DECISION DELEGATED TO HEAD OF PLANNING

Application No: H16-0172-22 **Applicant:** Elegant Smiles
Proposal: Proposed single storey extensions
Location: 2 Woolram Wygate Spalding
Terminal Date: 20th April 2022

Drawing Title:
PROPOSED GROUND FLOOR PLAN AND
ELEVATIONS.

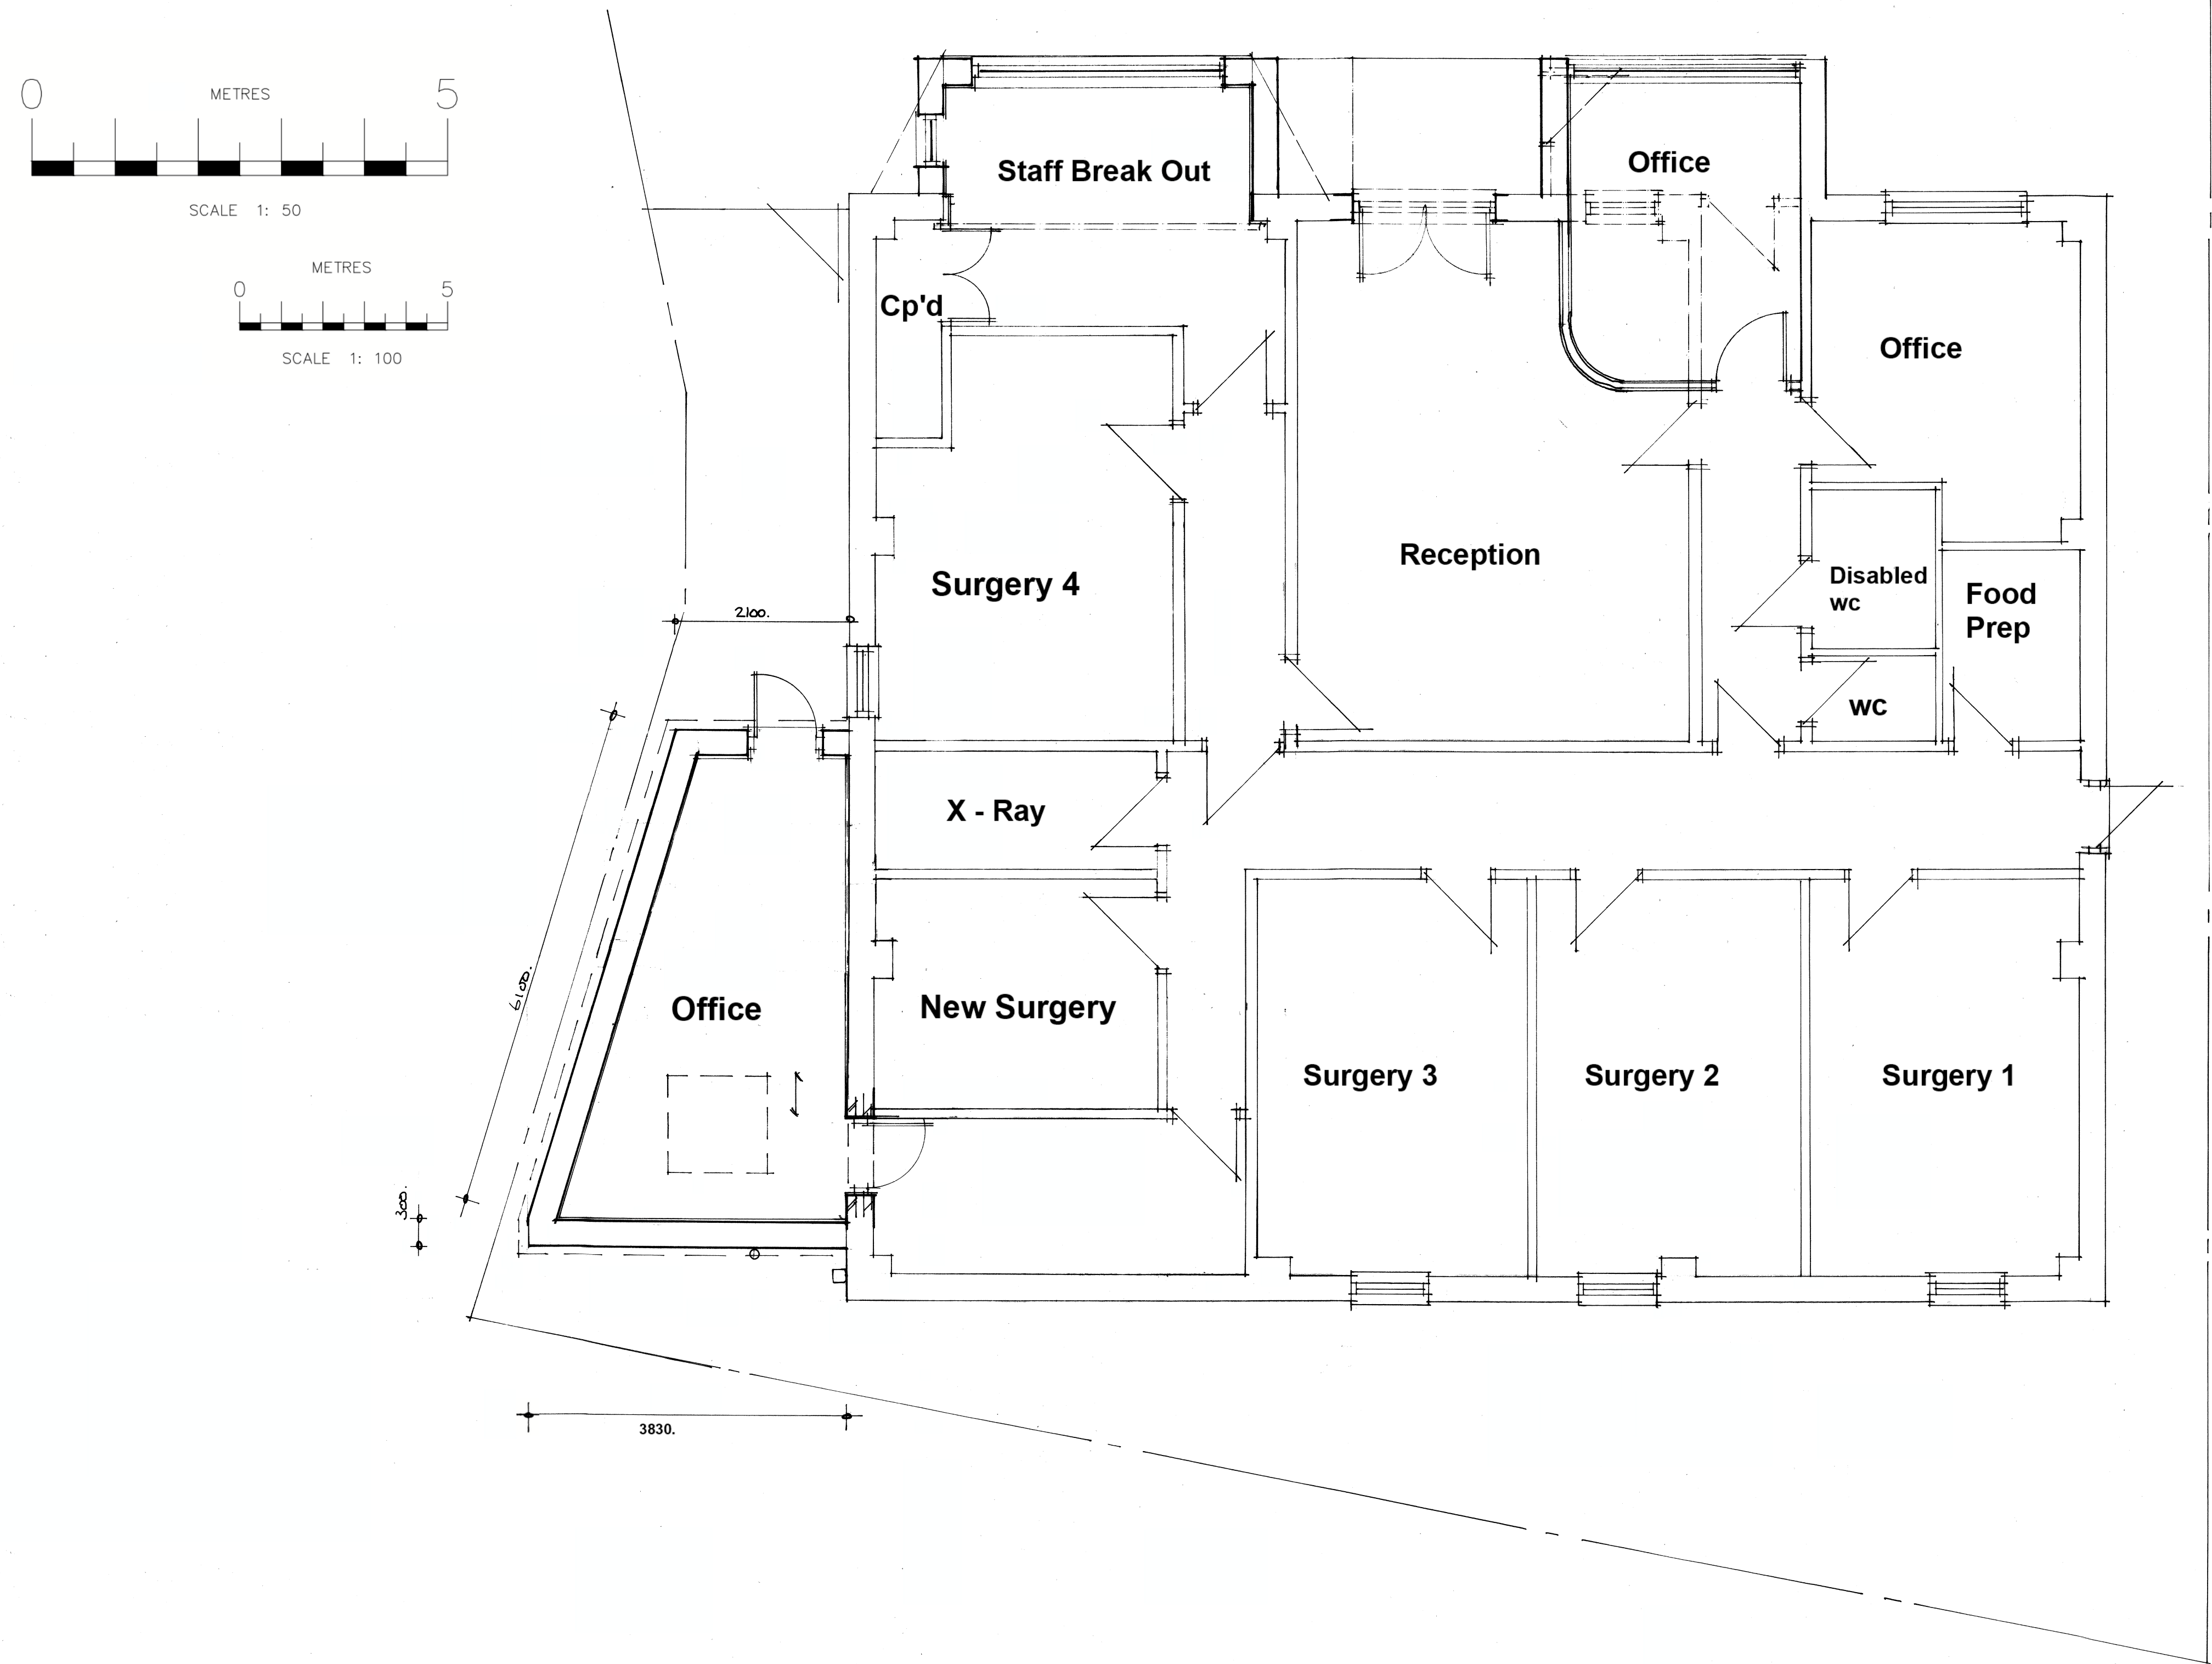
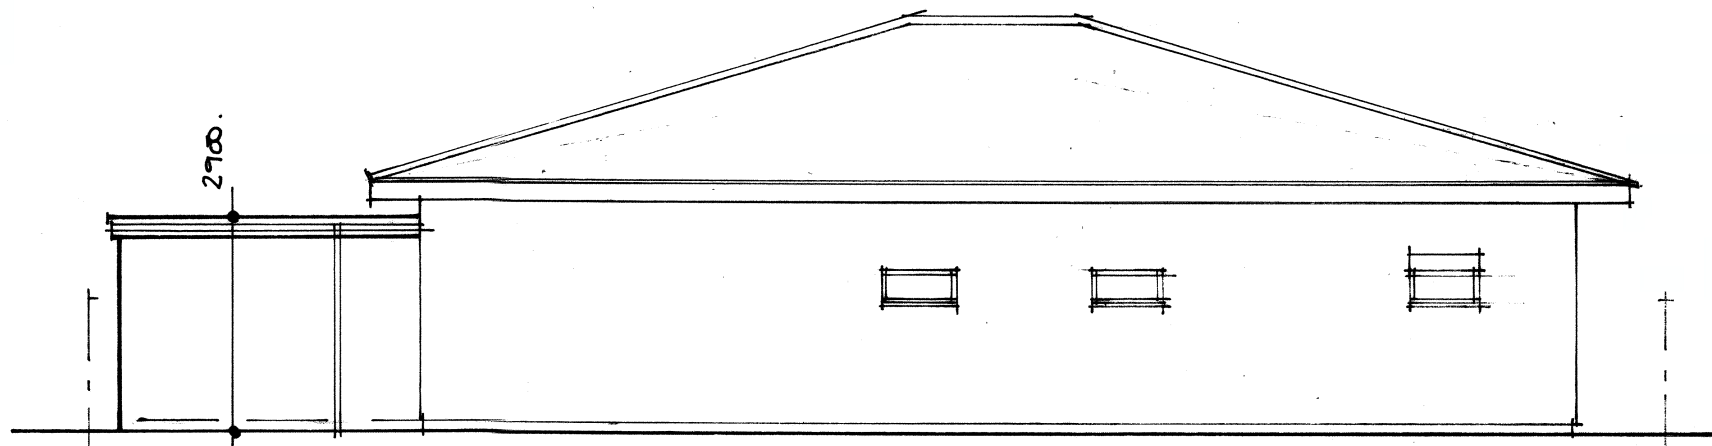
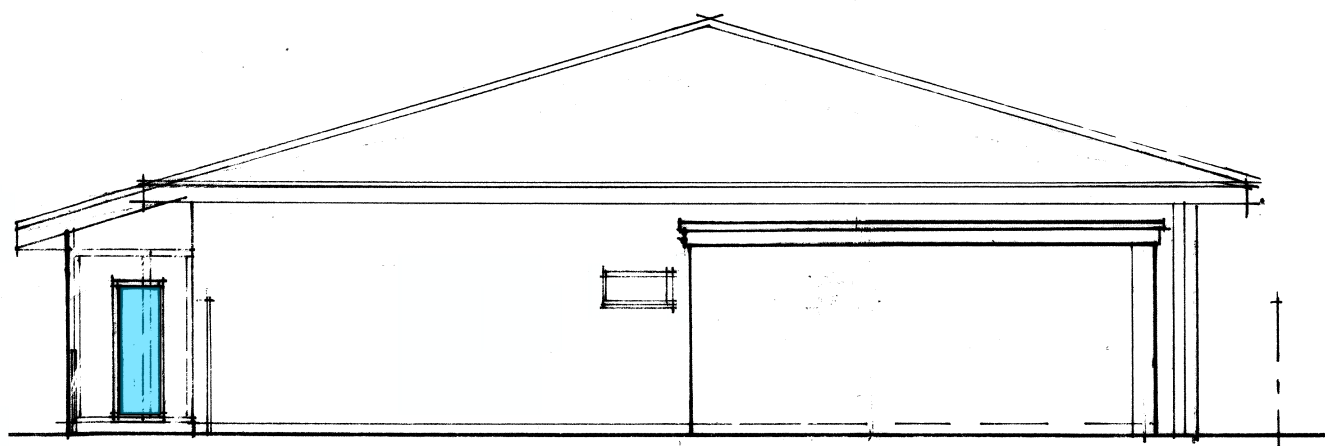
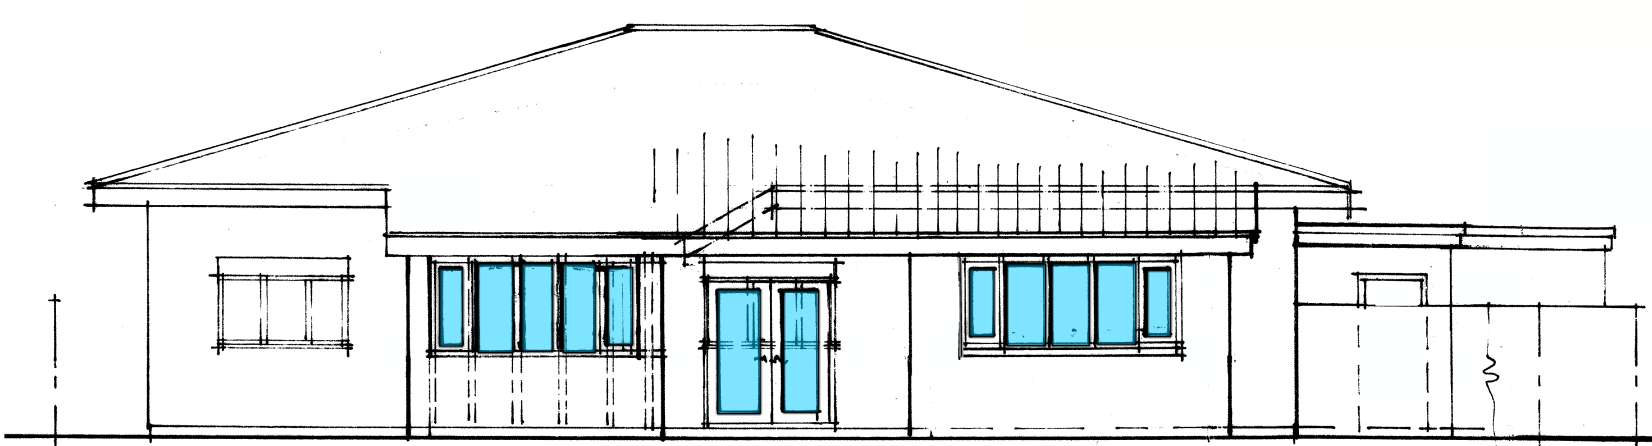
The proposed single storey side extension protrudes from the south side elevation in an almost triangular shape, to follow the line of the boundary. It will project by a minimum of approx. 2.1m and a maximum of 3.8m. The depth of the extension will be approx. 6.1m. The proposed front elevation extensions will protrude by approx. 1.6m from the front elevation and widths of approx. 4.3m and 3.4m respectively. Having regard to the existing dimensions of the building, the proposed extensions are acceptable in terms of scale, mass and bulk.

The side extension would have a flat roof and the roof to the front extensions would be a continuation of the existing roof. The flat roof structure to be situated to the side of building will not be particularly visible from the public realm and will therefore not materially impact the street scene. Facing brickwork on walls and white UPVC in fenestration will match those existing in the property. Thus, the development will appear well blended with the existing building and visual amenity will not be undermined.

It is not considered that there would be an overbearing or overshadowing impact upon the neighbouring residential properties to the south, north or east. The front extensions are minor in scale and the side extension will not exceed 2.9m in overall height. Based on the plans submitted as part of application ref. H16-0830-05 relating to no. 43 Pennygate, the very most rear wall does not include a window and the closest window facing north toward where the new extension would be sited is approximately 8m away and is to a utility room (therefore considered a non-habitable space).

In terms of overlooking, the proposed side extension includes a door to the front elevation and a roof light. Due to the single storey nature of the proposal and orientation of fenestration, it is not considered that any neighbouring property would suffer a material loss of privacy. The main windows to the front extension are forward facing, but a floor to ceiling side facing window is proposed to the south facing elevation of the staff breakout area. As this faces towards the rear windows of the neighbouring property at a distance of around 10m it would be appropriate to condition that this window be obscure glazed.

The proposed single storey extensions will not materially harm the character or appearance of the locality or amenity of nearby residents, subject to the south facing window to the staff breakout area being obscure glazed. It is therefore considered to be in accordance with Policies 2 and 3 of the South East Lincolnshire Local Plan, 2019.
